Thorpe on the Hill Parish Council IP Ref: [REDACTED]

Mitigation of the proposed FGE Solar Farm on the “Stepping Out” (SO) routes in Thorpe on the Hill

Figure 3-3

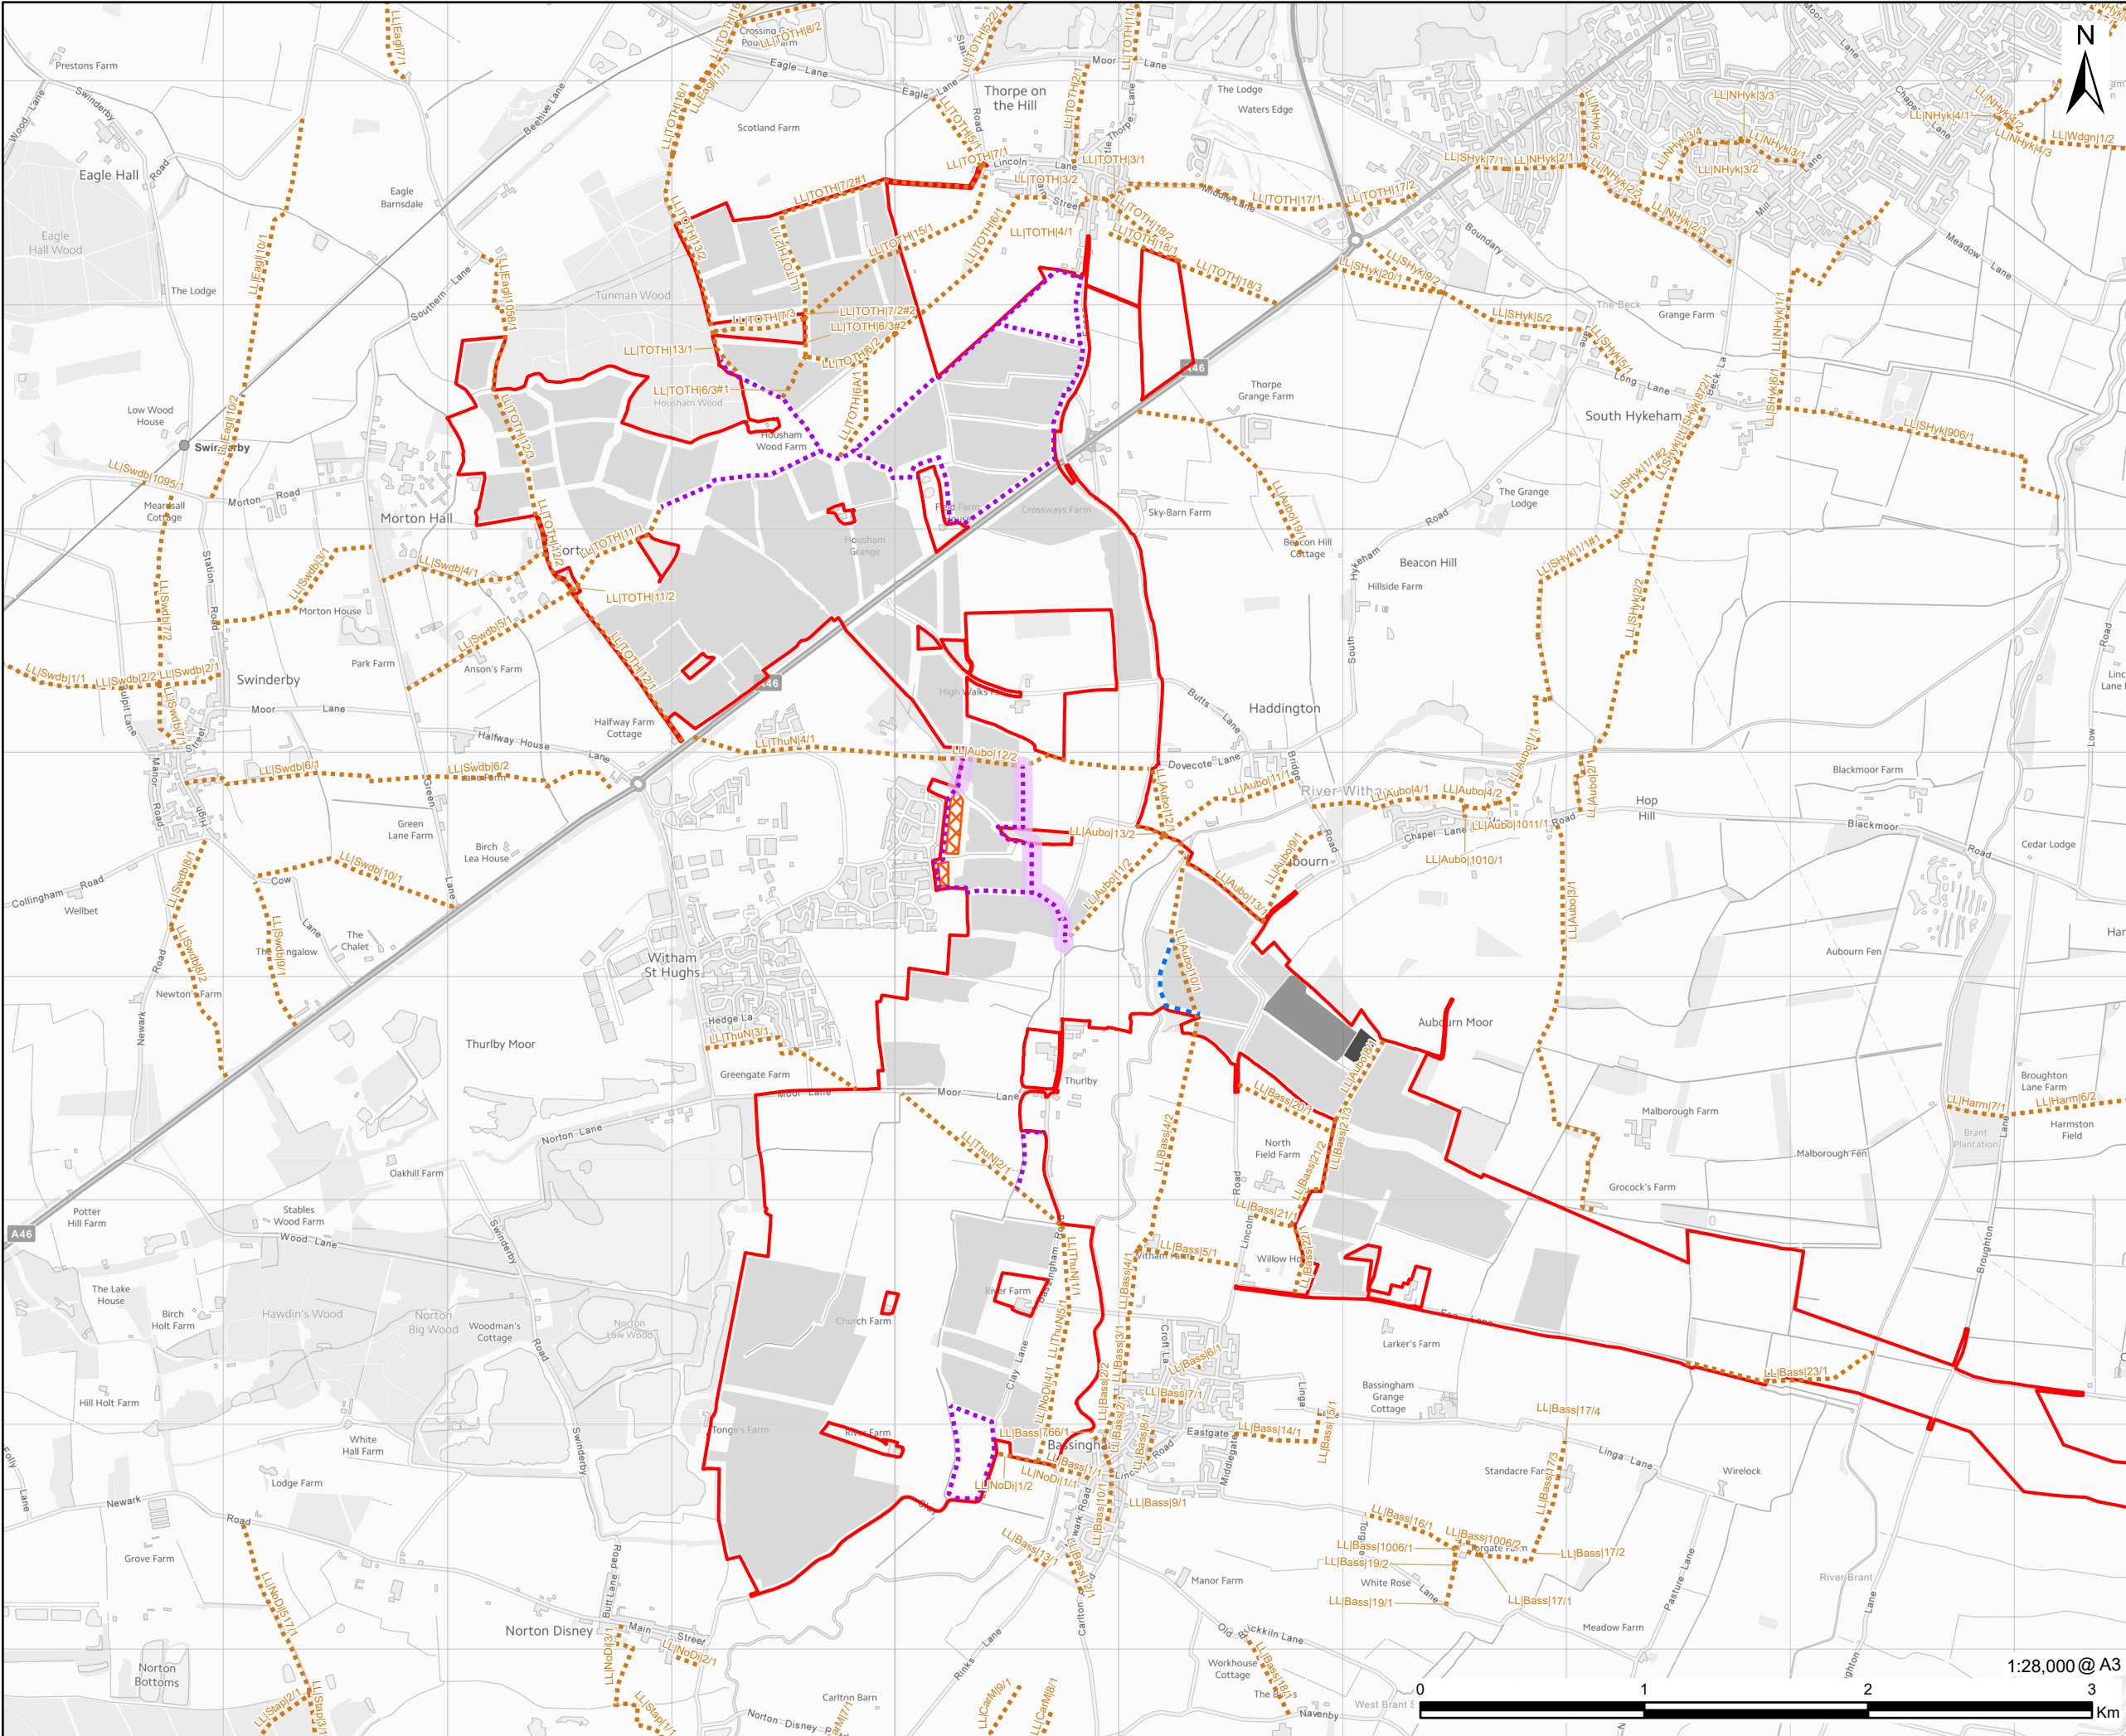
The Applicant's recent response REP5-008 contains a diagram of proposed new permissive footpaths. A section illustrating the impact on Thorpe on the Hill is included in this submission for reference and is shown on page 2.

The Parish Council (PC) welcomes the addition of new permissive paths but suggest that those running alongside the A46 and the bottom of Fosse Lane will attract few walkers compared to the Stepping Out routes.

The PC previously made a submission REP3-059 which suggested some design criteria and revisions which could mitigate the impacts of the development on key local features and views. The PC notes that some of new permissive paths which are shown on REP5-008 as purple dashed lines, to the south of Housham Wood, meet the criteria suggested by the PC in their submission REP3-059.
